City of Portland, Maine - Building or Use Permit Application
 389 Congress Street, 04101 Tel: (207) 874-8703, Fax: (207) 874-8716

PERMIT ISSUED		Permit No: 020902	Issue Date: AUG 15 2002	CBL: 185 B018001
Location of Construction: 39 Colonial Rd		Owner Name: Sheehy Gretchen A	Owner Address: 39 Colonial Rd	Phone: 775-6021
Business Name:		Contractor Name: Applicant	Contractor Address: Portland	Phone:
Lessee/Buyer's Name		Phone:	Permit Type: Amendment to Single Family	Zone: R-5

Past Use: Two Family	Proposed Use: Two Family	Permit Fee: \$30.00	Cost of Work: \$30.00	CEO District: 3	
Proposed Project Description: Amend Permit # 011400. Space change to Bedroom/Laundry <i>part of owner's unit</i>		FIRE DEPT: <input type="checkbox"/> Approved <input checked="" type="checkbox"/> Denied <i>N/A</i>	INSPECTION: Use Group: <i>R-3</i> Type: <i>SB</i> <i>BOCA 99</i>		
Signature:		Signature: <i>gm</i>

Application ID Number: 2-0902

PROJECT: Gretchen Sheehy
DATE: 11/9/2001
SCALE: N.T.S.
TITLE: As built, attic, 39 Colonial Rd. Portland

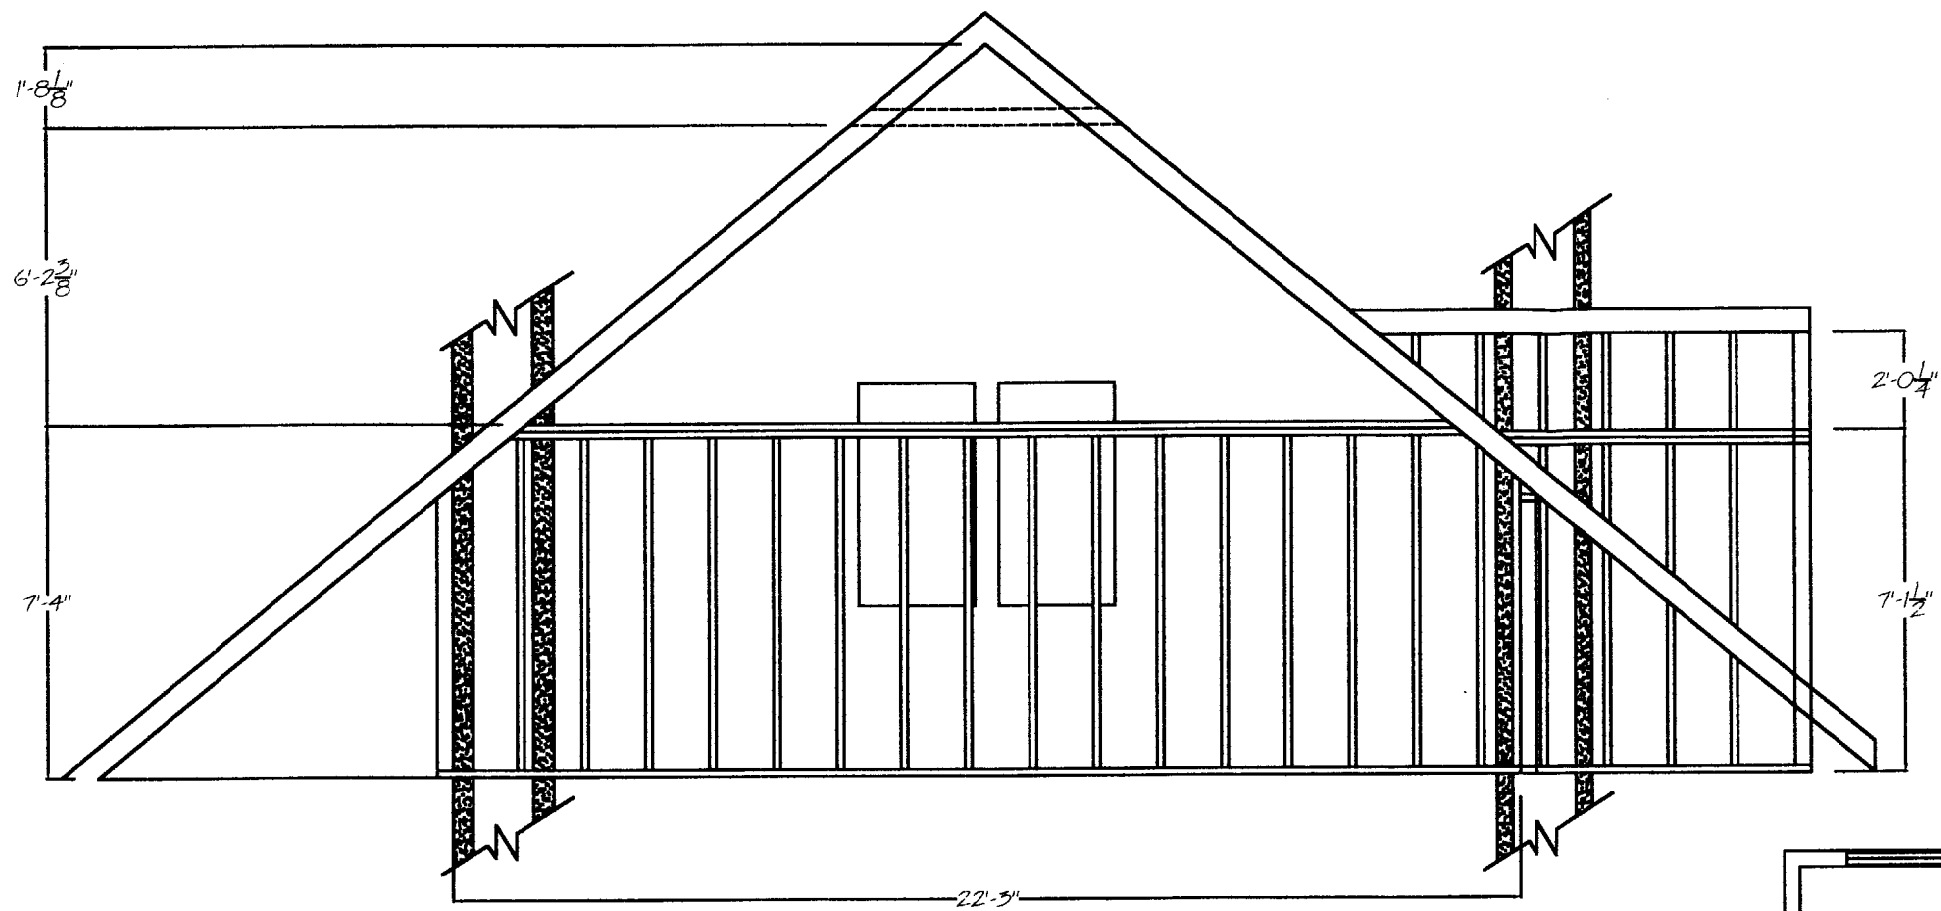
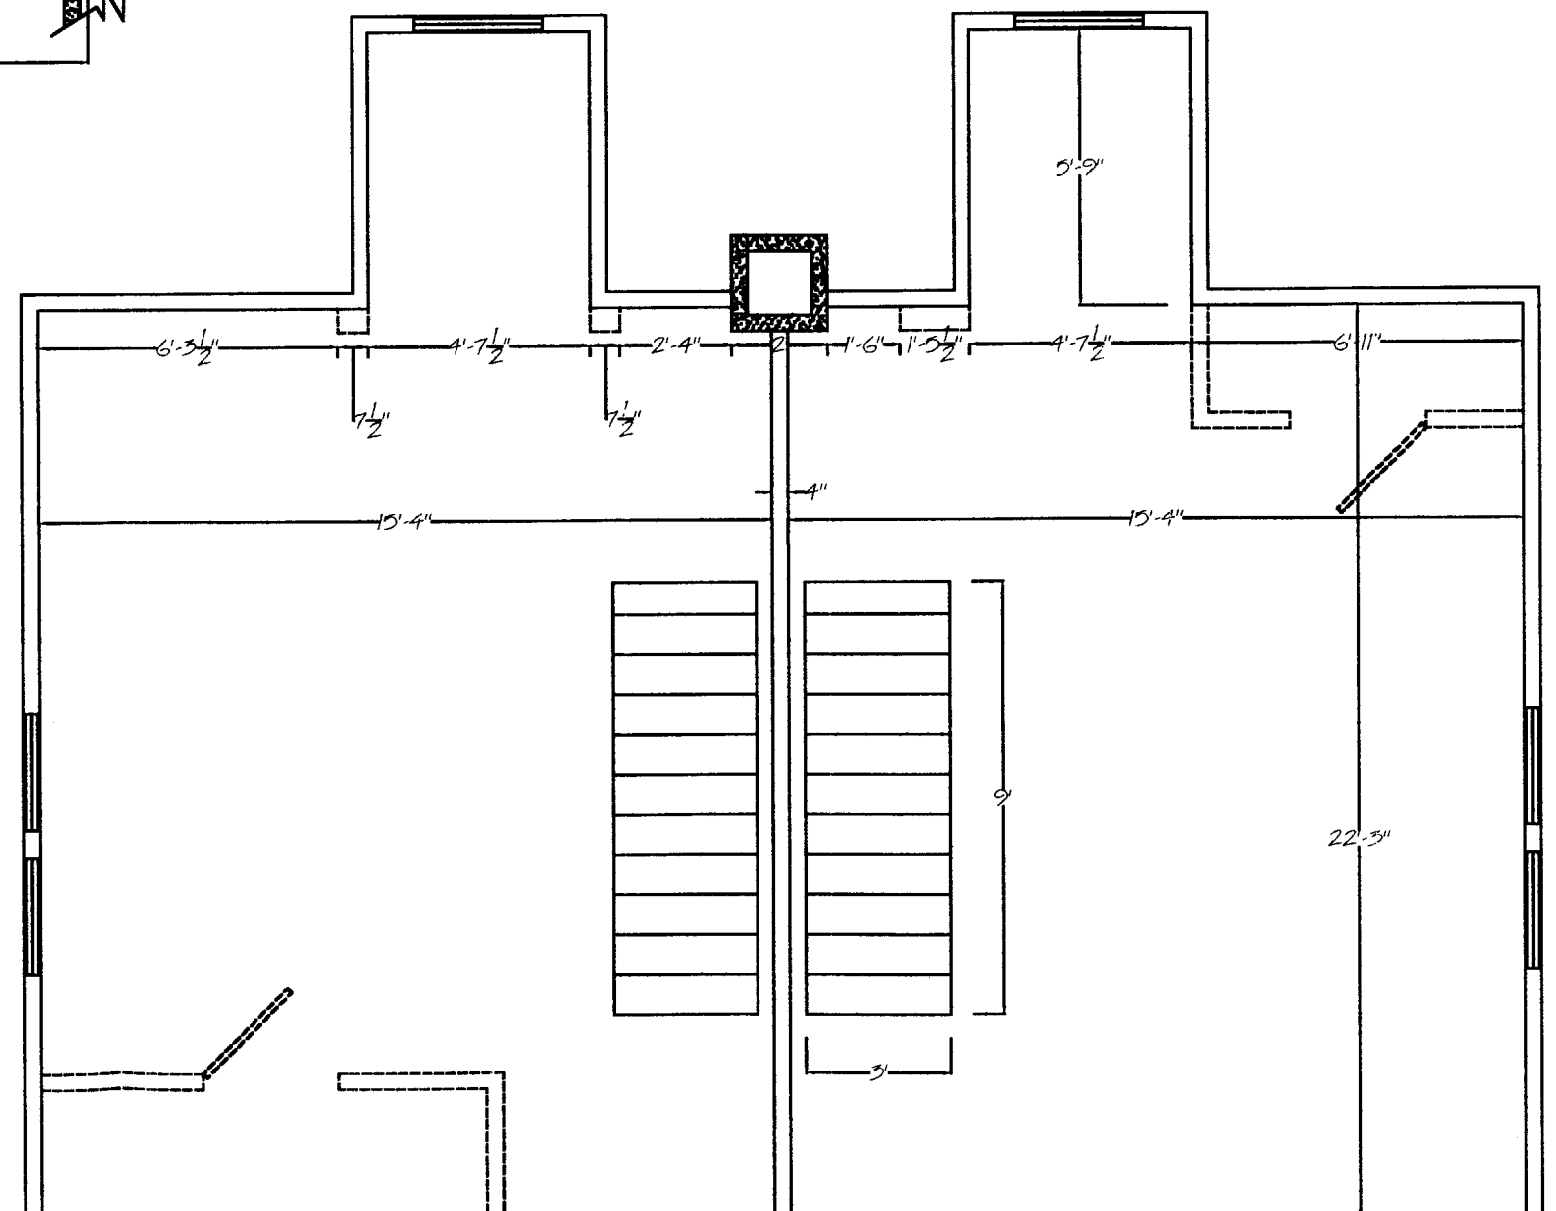
This is NOT an approval for an additional dwelling unit. You SHALL NOT add any additional kitchen equipment including, but not limited to items such as stoves, microwaves, refrigerators, or kitchen sinks, etc. Without special approvals.

All the kitchen-like equipment that was installed for the previous artist studio shall be removed in their entirety. The "slop sink" for the washing machine may remain only for washing machine purposes, not for any kitchen purposes. This area shall be part of one of the dwelling units and not a separate unit.
